Planning and Regulatory: G.Mansfield
Reference: PB2017/06965
Phone: 02 4974 2767

**MIXED USE COMMERCIAL AND RESIDENTIAL DEVELOPMENT
DOMA HOLDINGS P/L (SSD 8019) 50 HONEYSUCKLE DRIVE, NEWCASTLE**

The submitted application and Environmental Impact Statement (EIS) have been reviewed by Council officers and the following comments are offered for your consideration:

2 NORTH ELEVATION

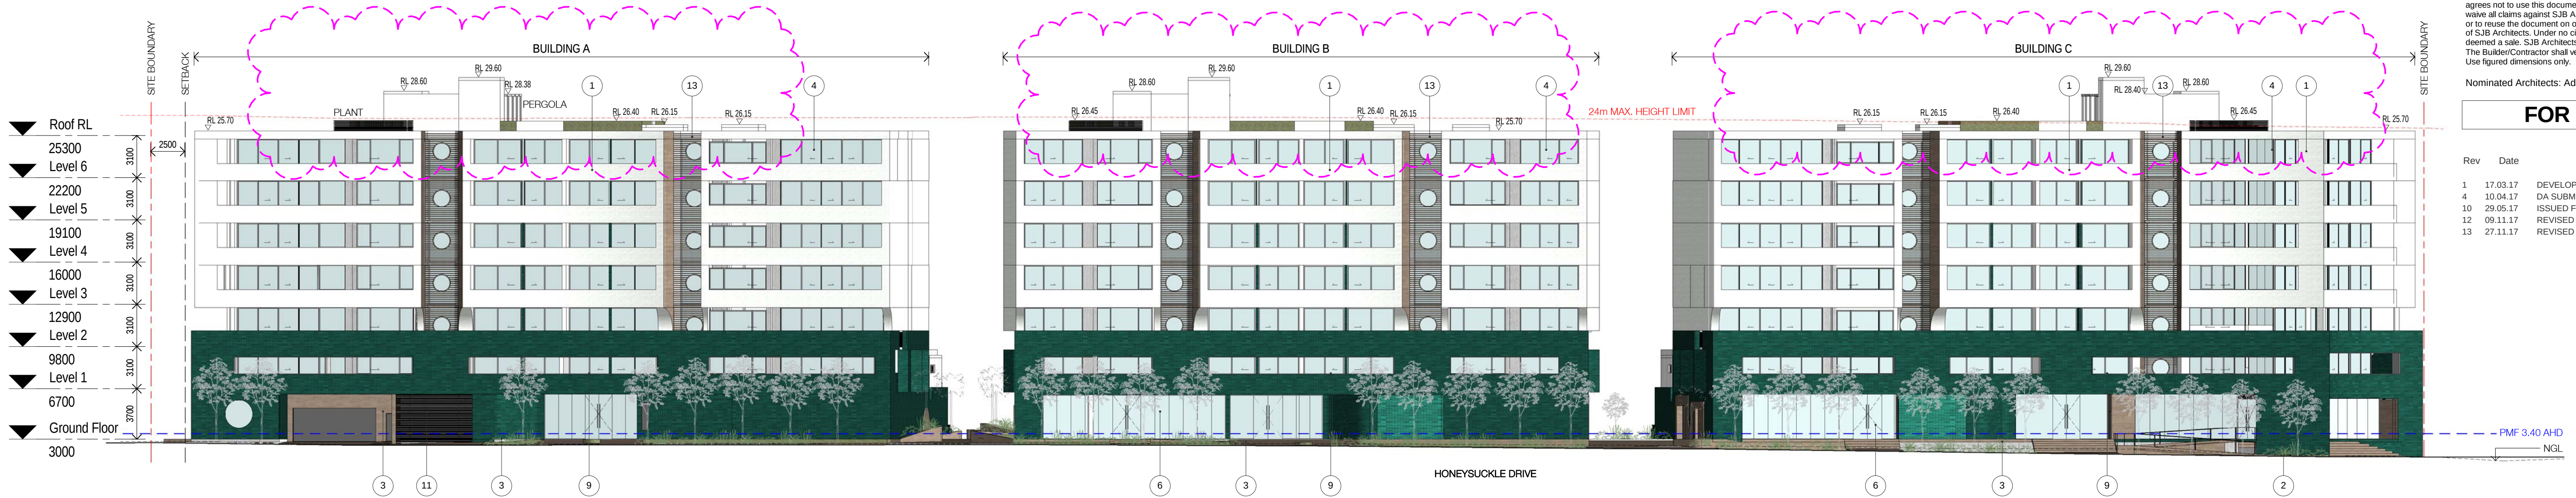
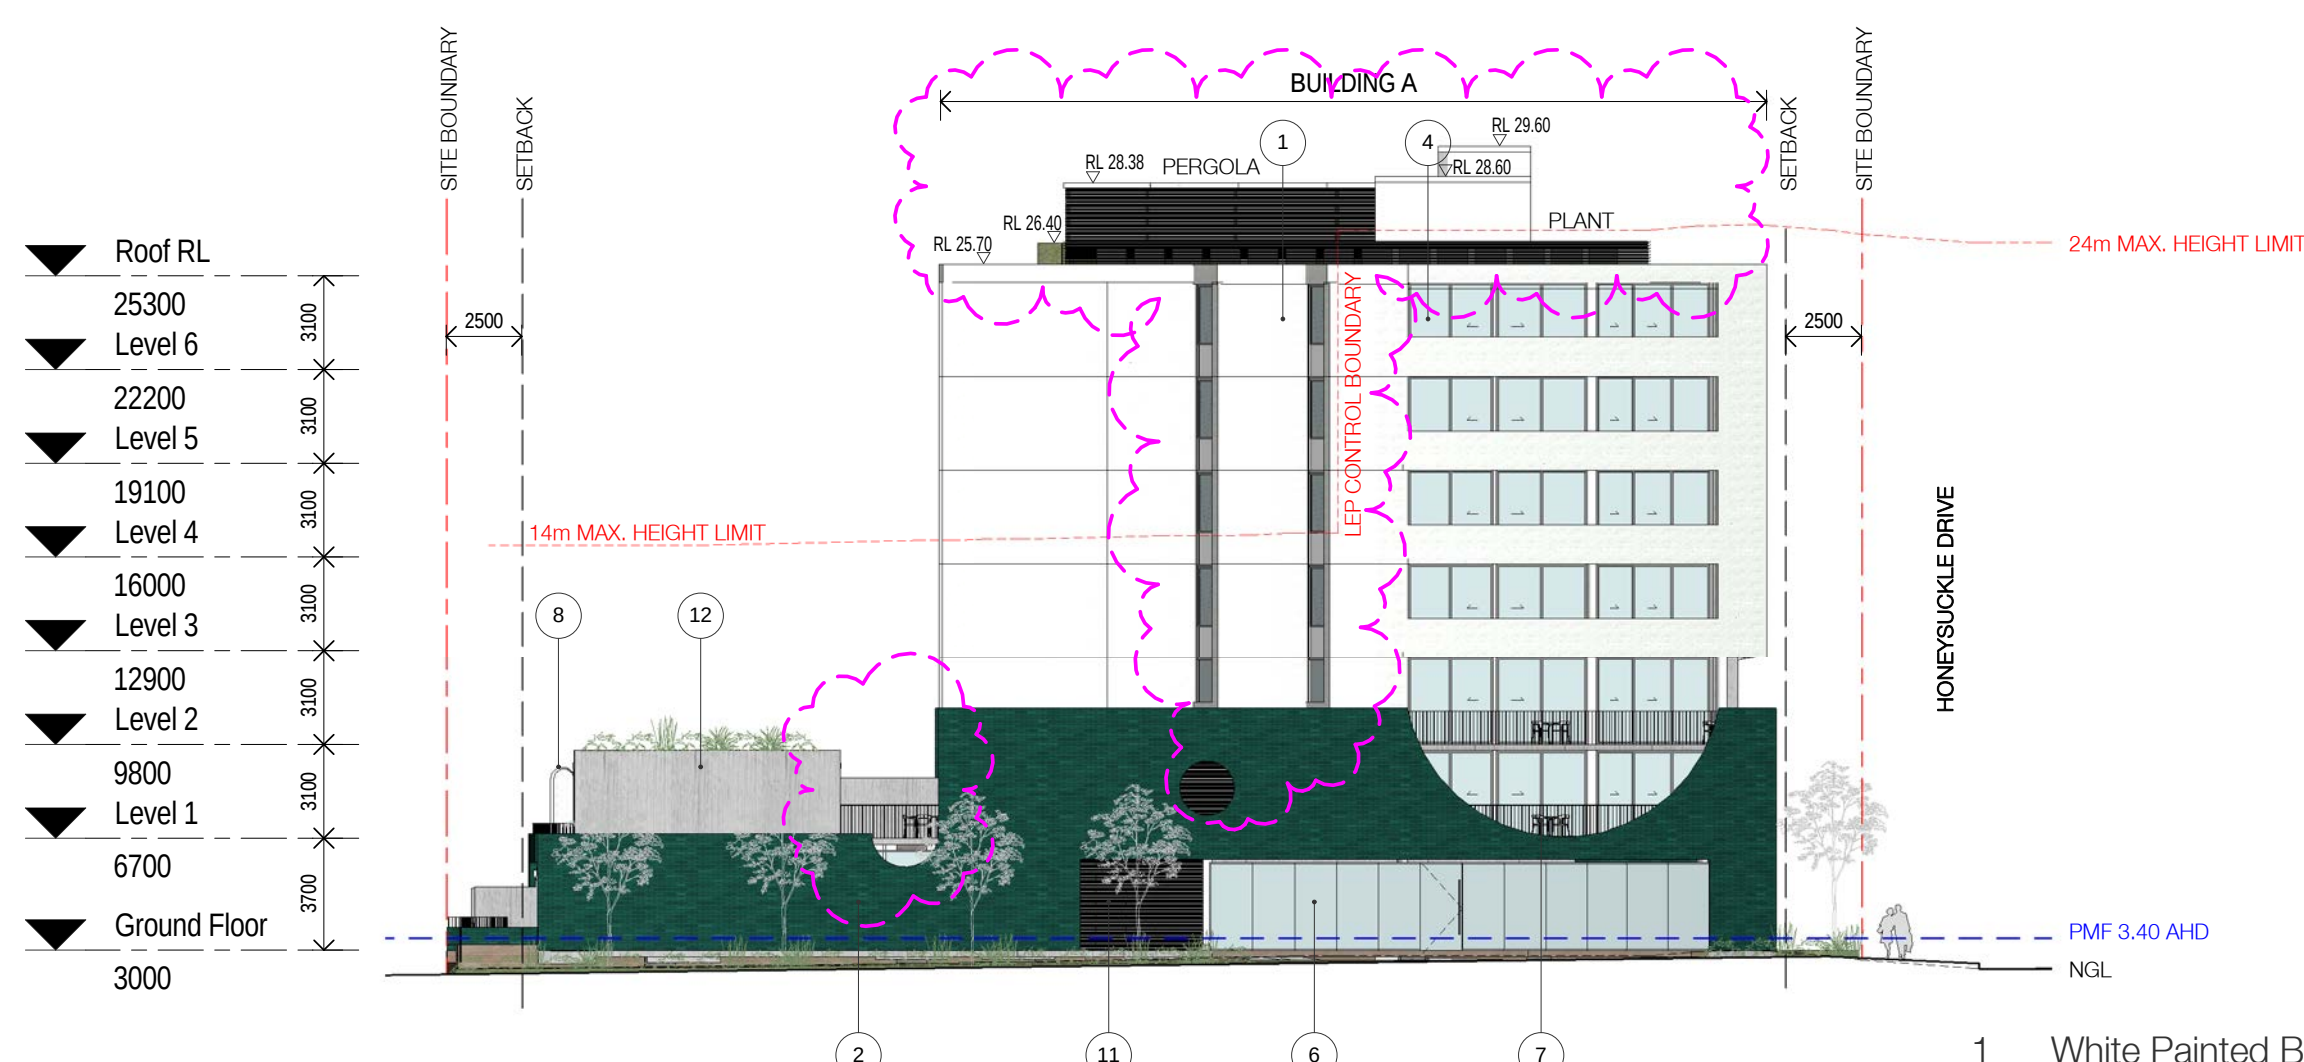
It is evident that the UDCG was not expecting, as exists in the adjoining development to the east, the entire ground floor facing the foreshore to include commercial tenancies, however the provision of a single kiosk is not considered to be a satisfactory response and it is recommended that the applicant be required to reconsider this issue and either further amend the design of the development or provide a more comprehensive justification for the design of the development in its current form.

'The Group does not support the use of continuous glazed balustrades to external balconies. A combination of solid and void balustrades along with moveable screens (to conceal drying areas, BBQs and air conditioning units) is needed. This is critical on the northern elevation, facing the harbour, but also necessary for the southern elevation, which faces a row of office buildings.'
